MDT-SF22036-R1-Plat.pdf Markup Summary

PRELIMINARY
THIS DOCUMENT HAS NOT BEEN PLAT CHECKED
Add dollar amount due lines
FOURSQUARE AT STERLING RANCH EAST FILING NO. 1
JOB NO. 118323
NOVEMBER 5, 2022
SHEET 1 OF 6

FOURSQUARE AT STERLING RANCH EAST FILING NO. 1
 JOB NO. 1183.23
 NOVEMBER 9, 2022
 SHEET 1 OF 6

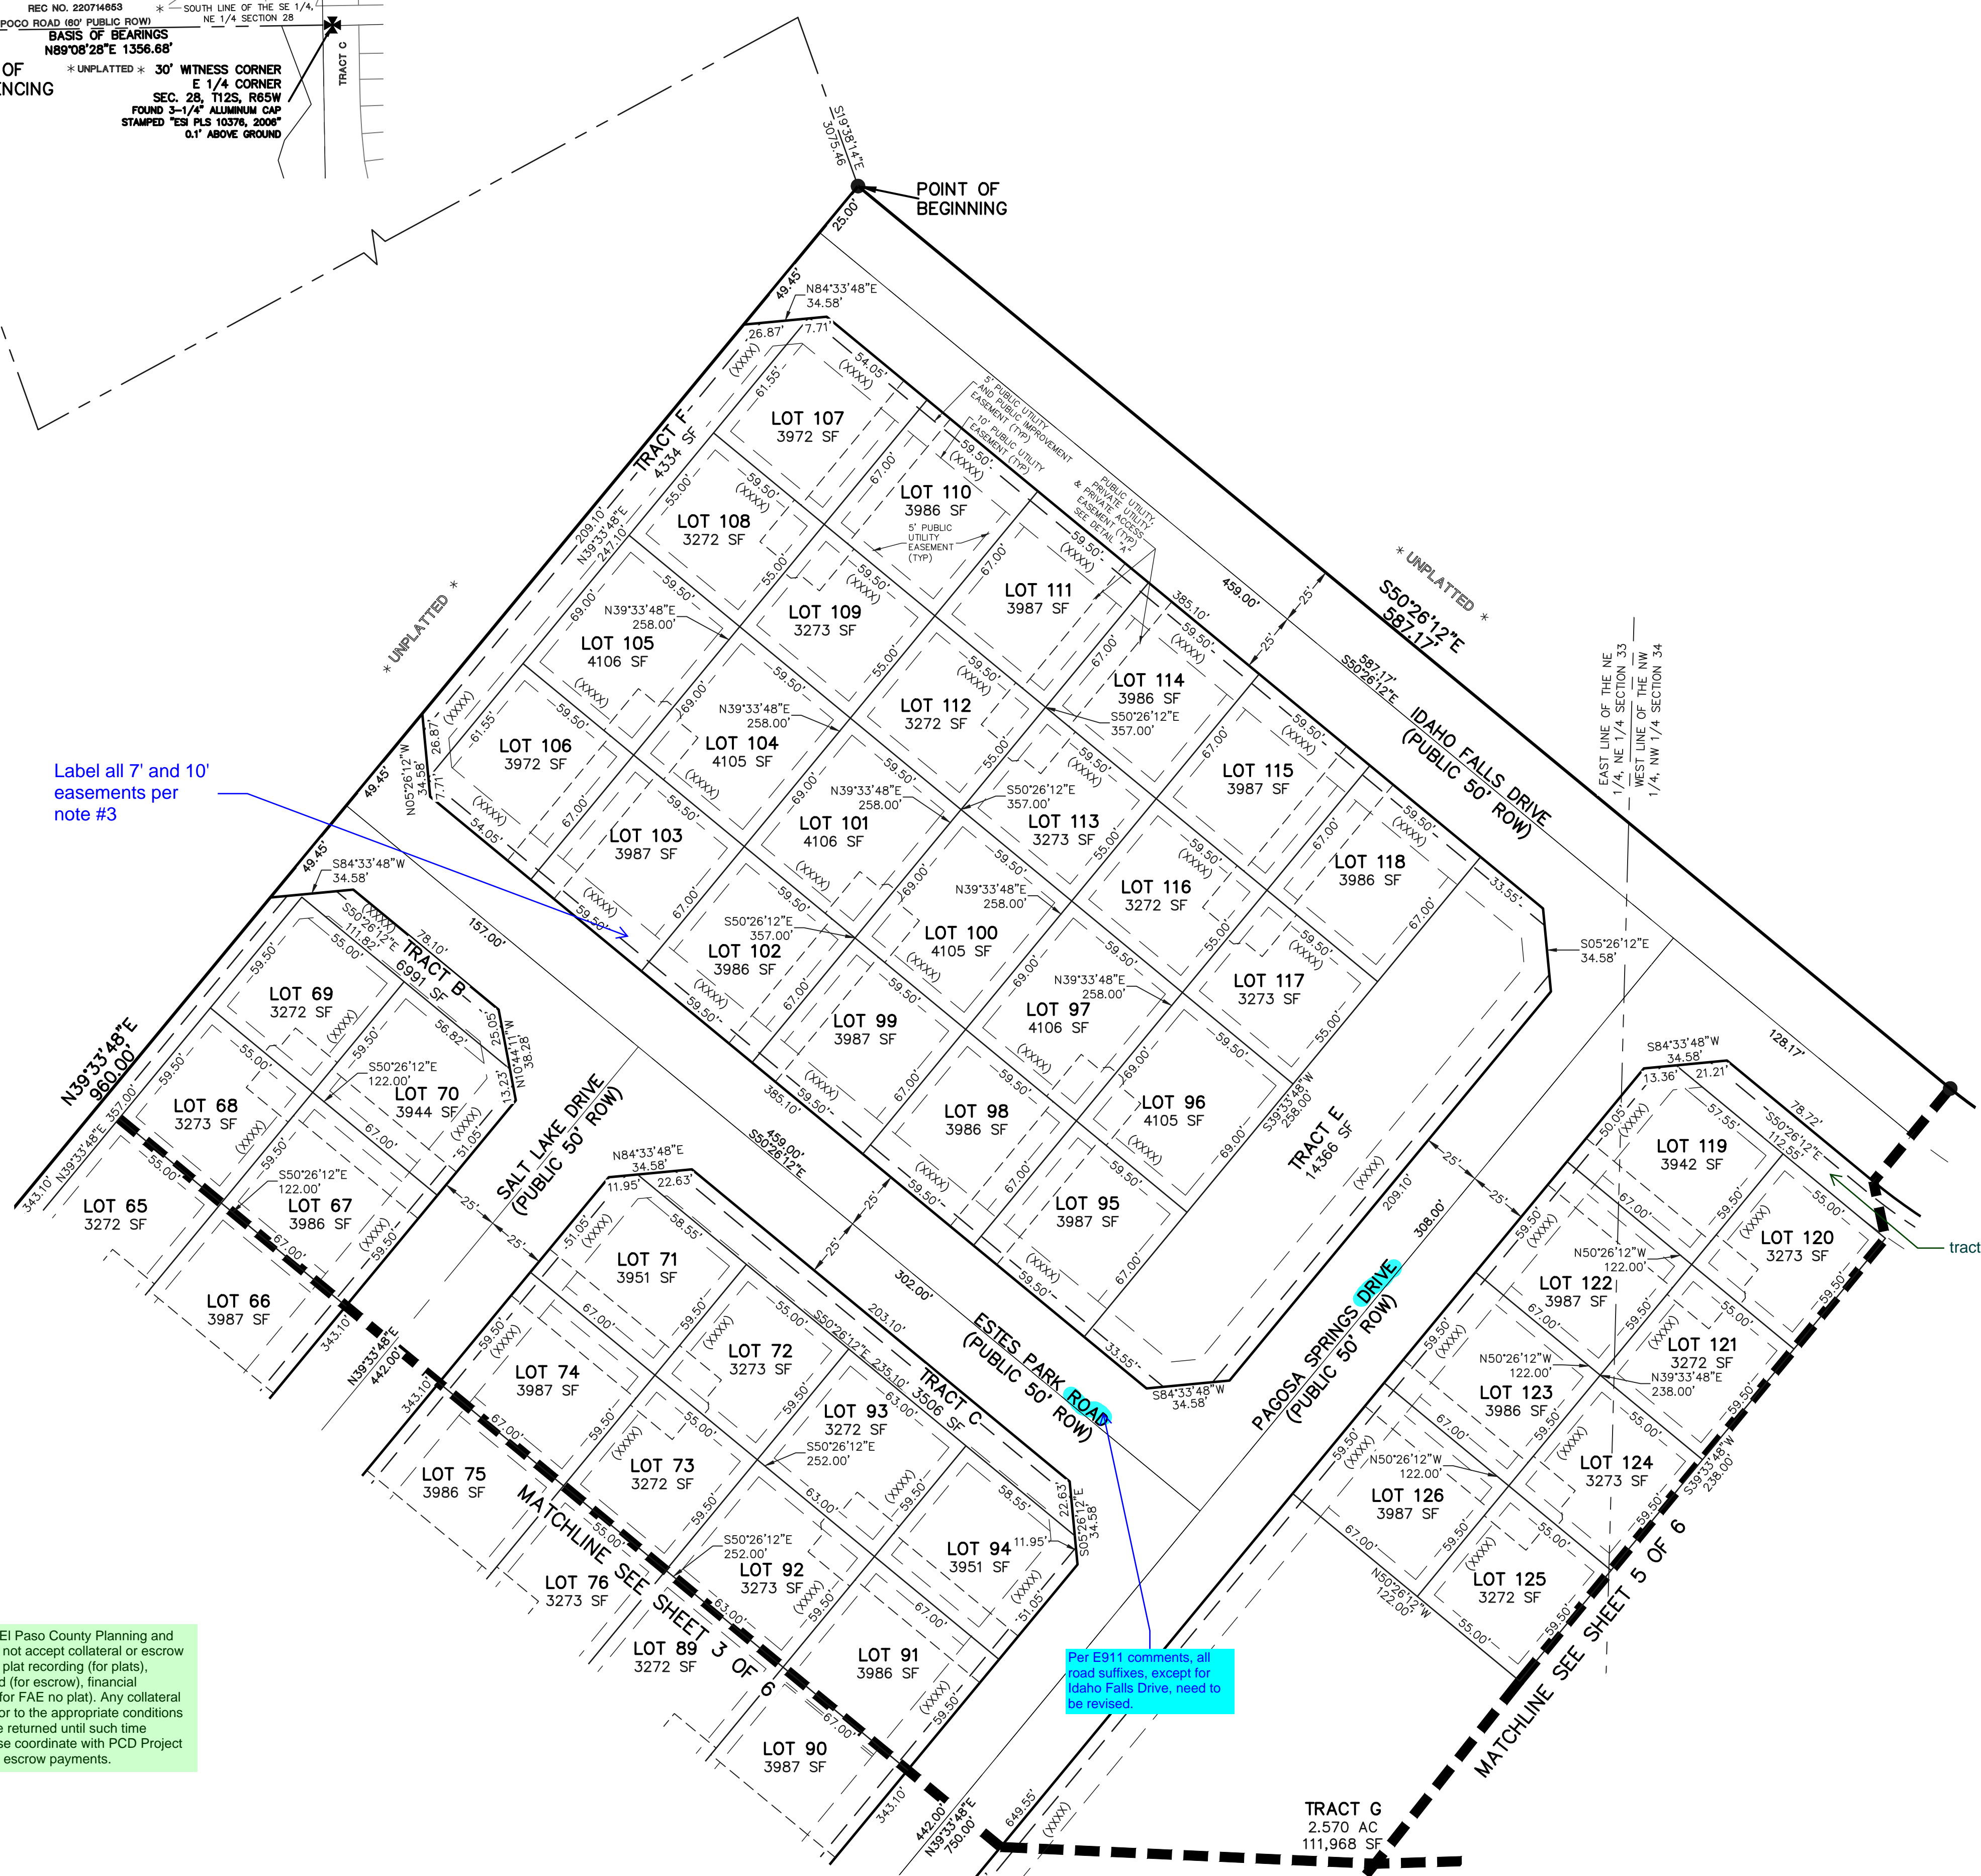
Include soils & geology notes.

Reference to channel & wetlands maintenance agreement can be removed, as no channel or wetlands improvements associated with this project.

Pond is private and to be maintained by metro district

Soil and Geology Conditions:
 Geologic Hazard Note-Final Plat: (to be customized based upon the individual circumstances)
 The following lots have been found to be impacted by geologic hazards. Mitigation measures and a map of the hazard area can be found in the report (Title of Report, generally from the Preliminary Plan file) by (author of the report) (date of report) in file (name of file and file number) available at the El Paso County Planning and Community Development Department:

Use round 3 PUDSP note

Add the note stating the public trails are located in tracts x adj to a,b,c lots. (Lots next to trail head)

Add dollar amount due lines

Add fees

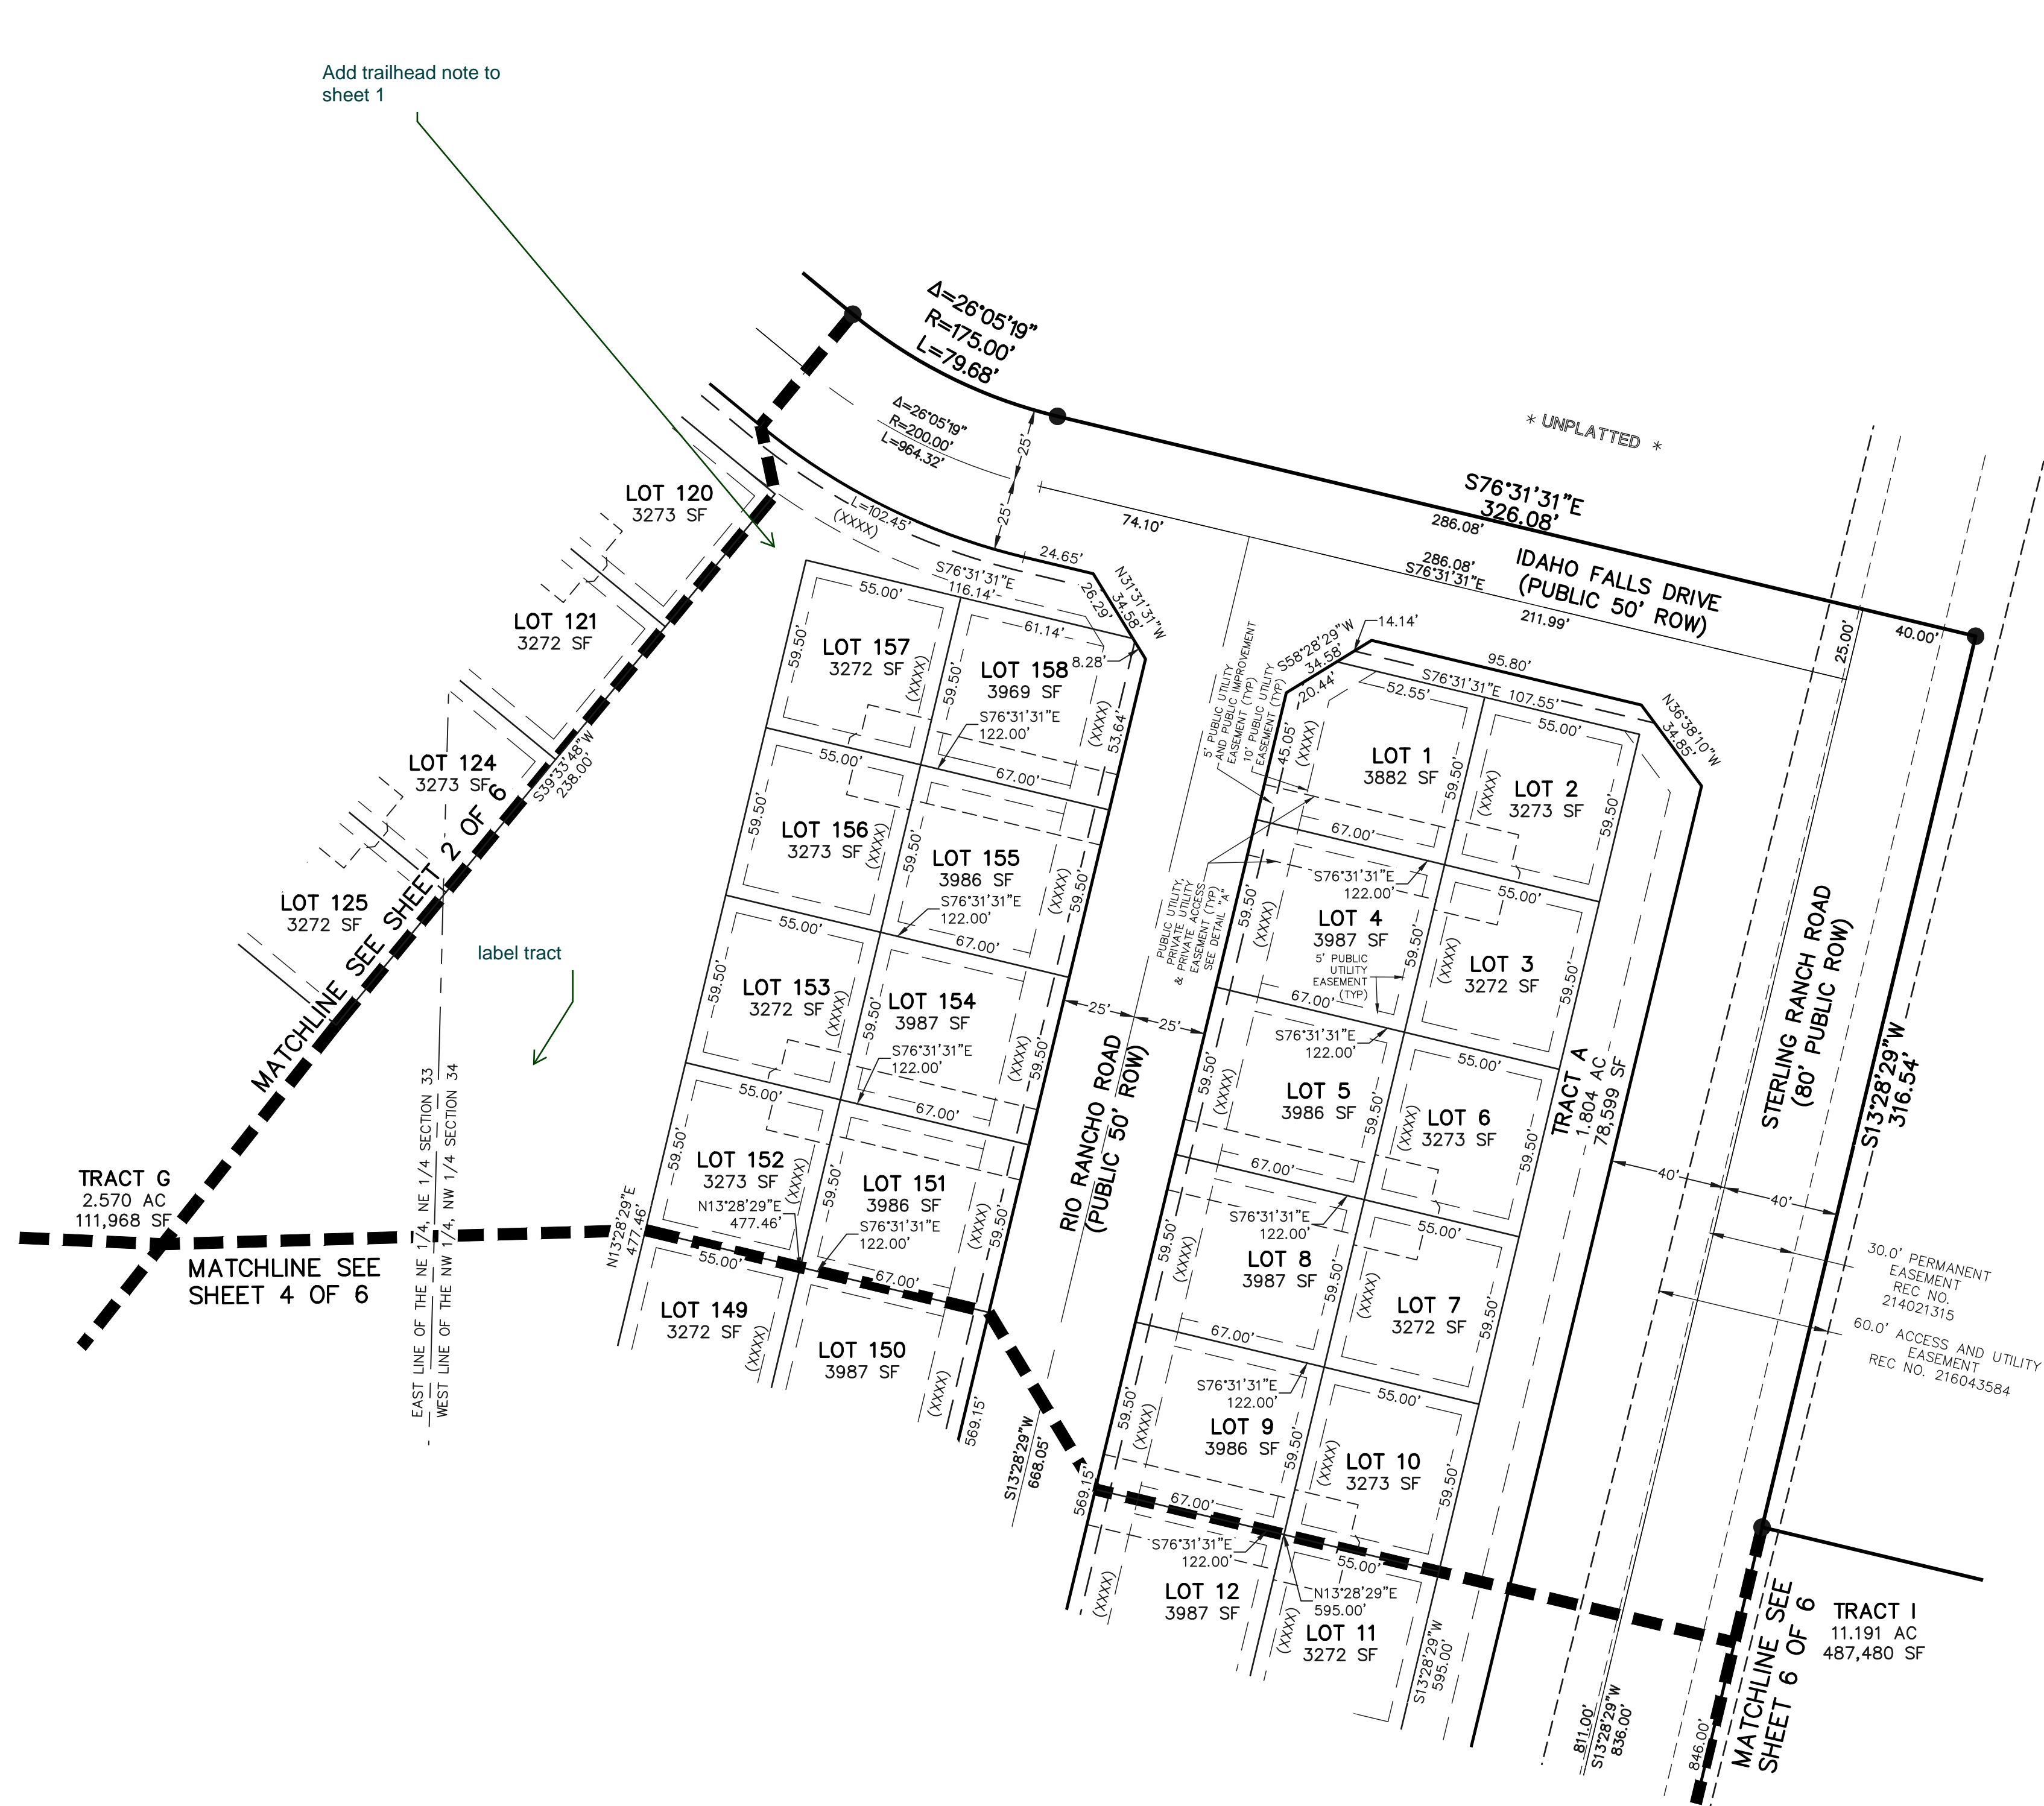
Label Roadway (See comment on previous sheet)

Include roadway classification

this is tract G correct?

label tract and SF

FOURSQUARE AT STERLING RANCH EAST FILING NO. 1
JOB NO. 1183.23
NOVEMBER 9, 2022
SHEET 5 OF 6

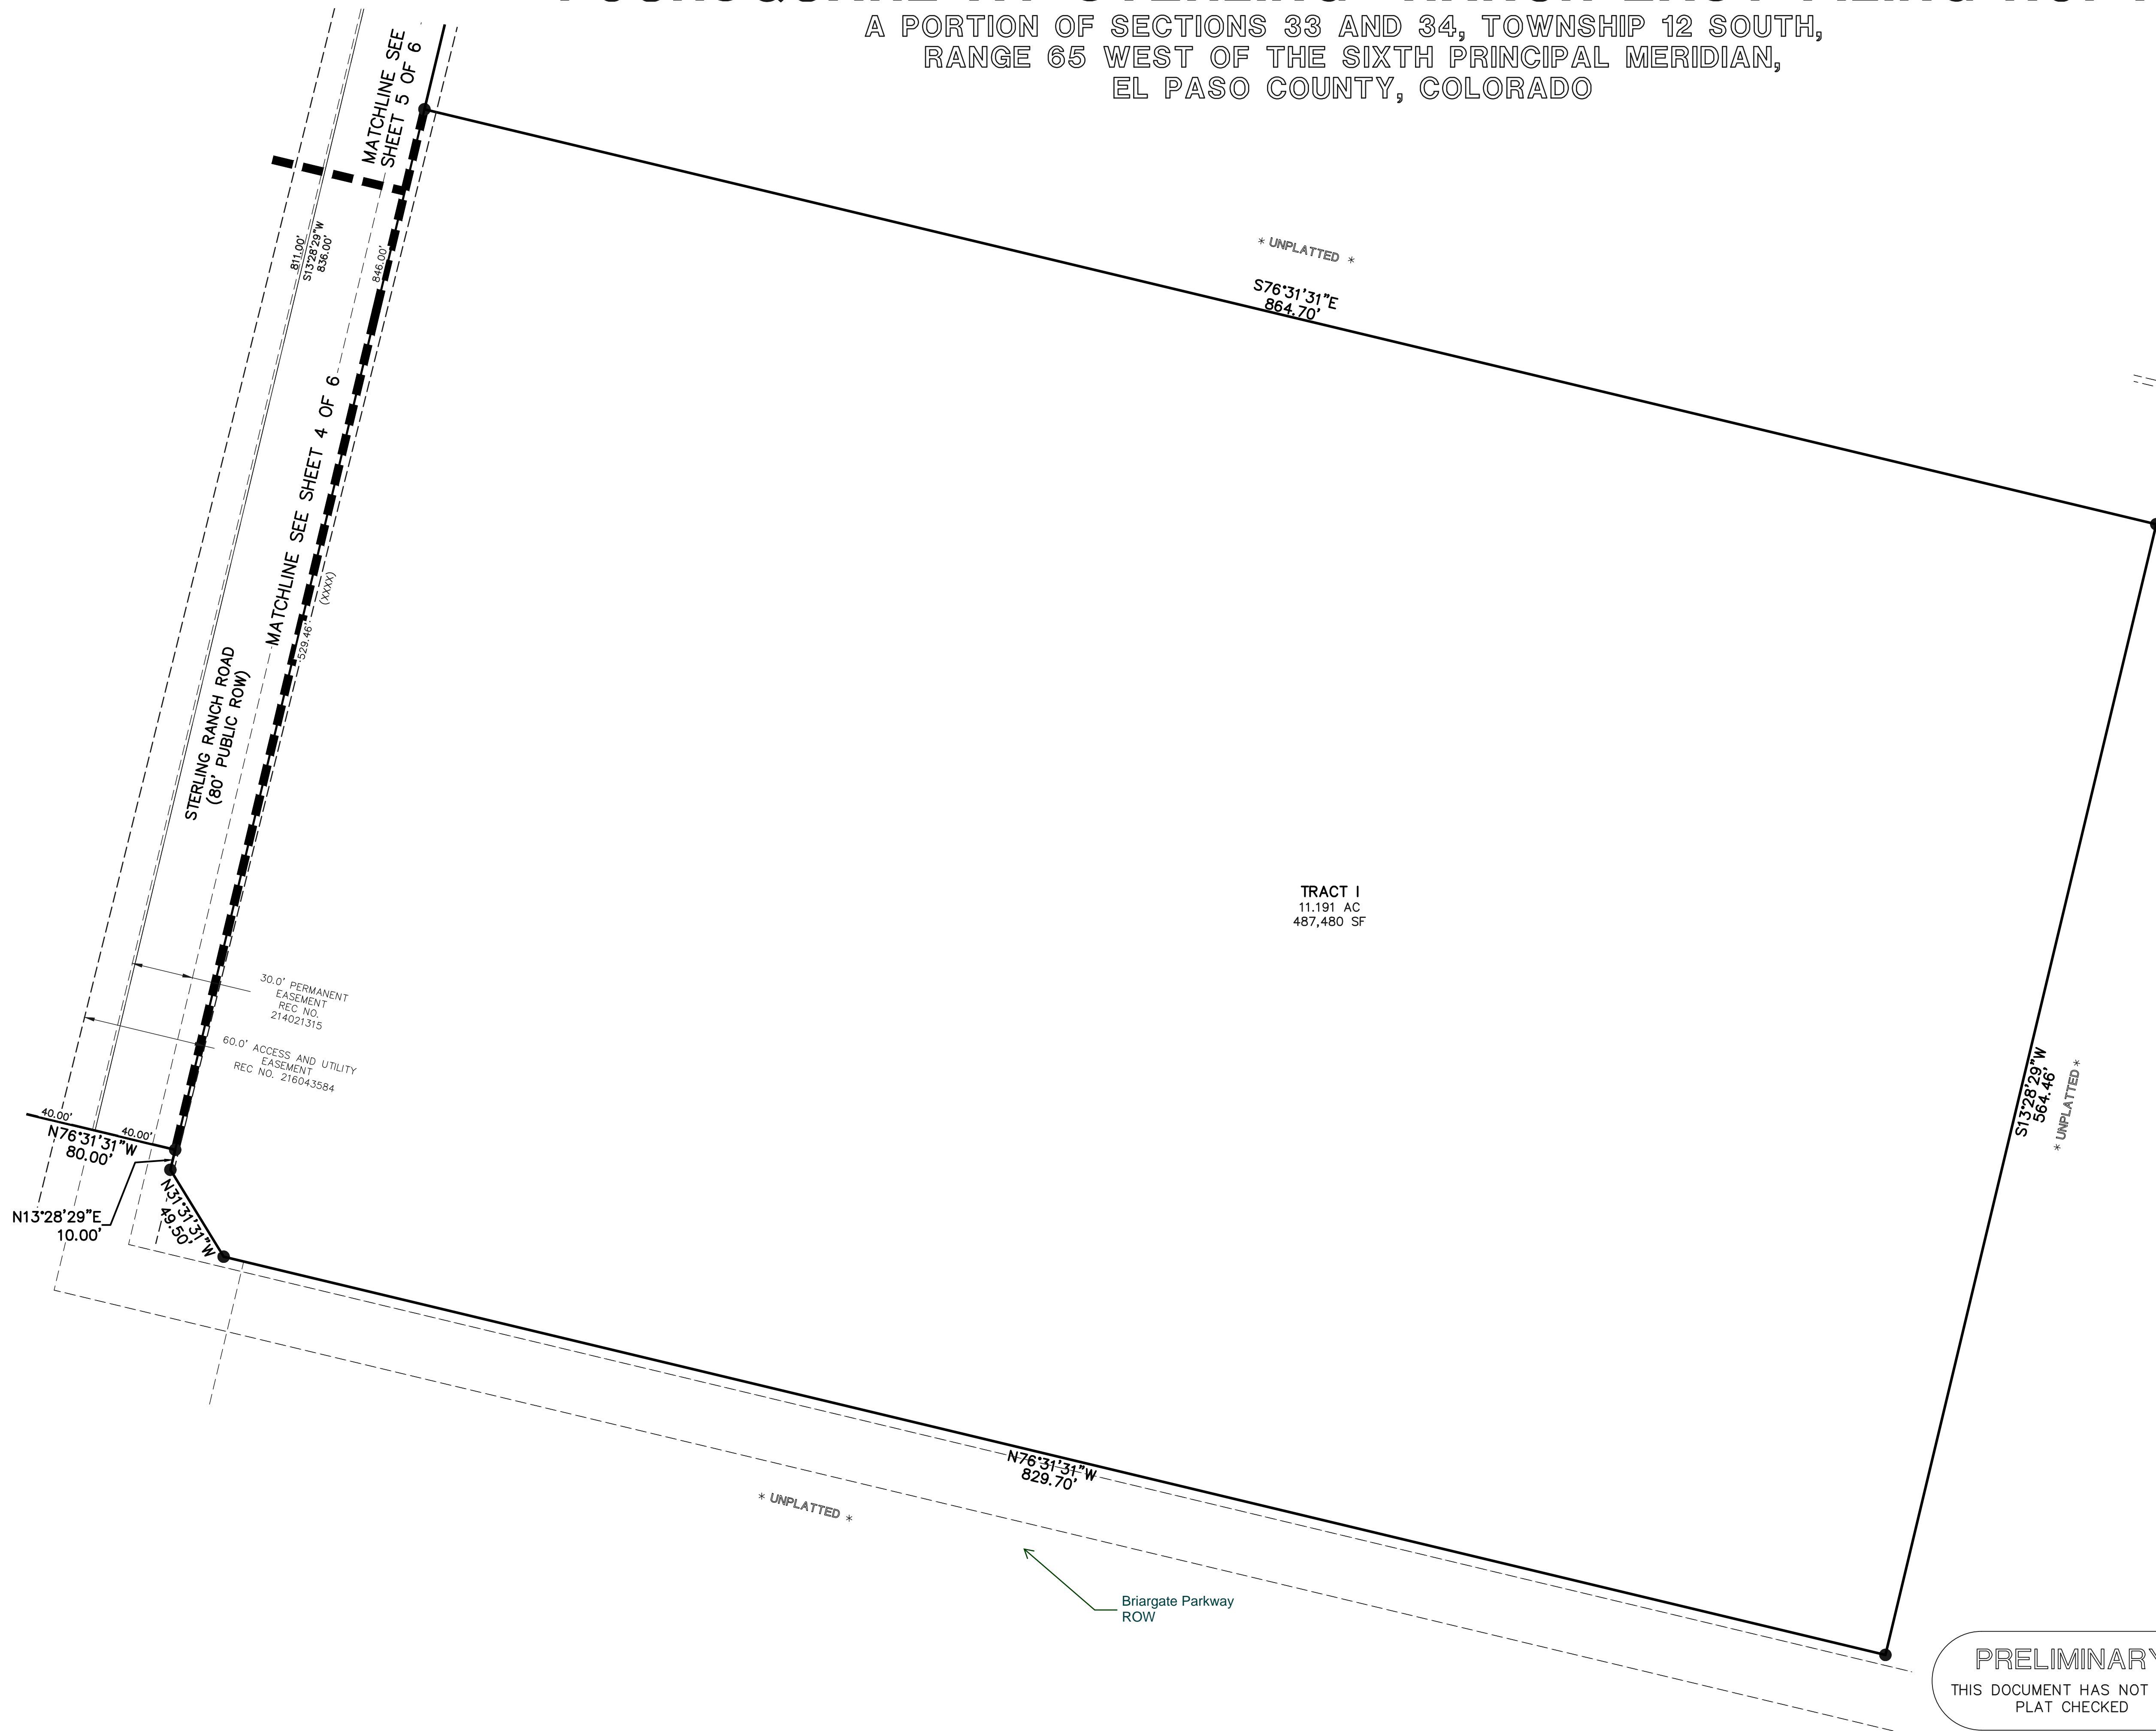
label tract

Add trailhead note to sheet 1
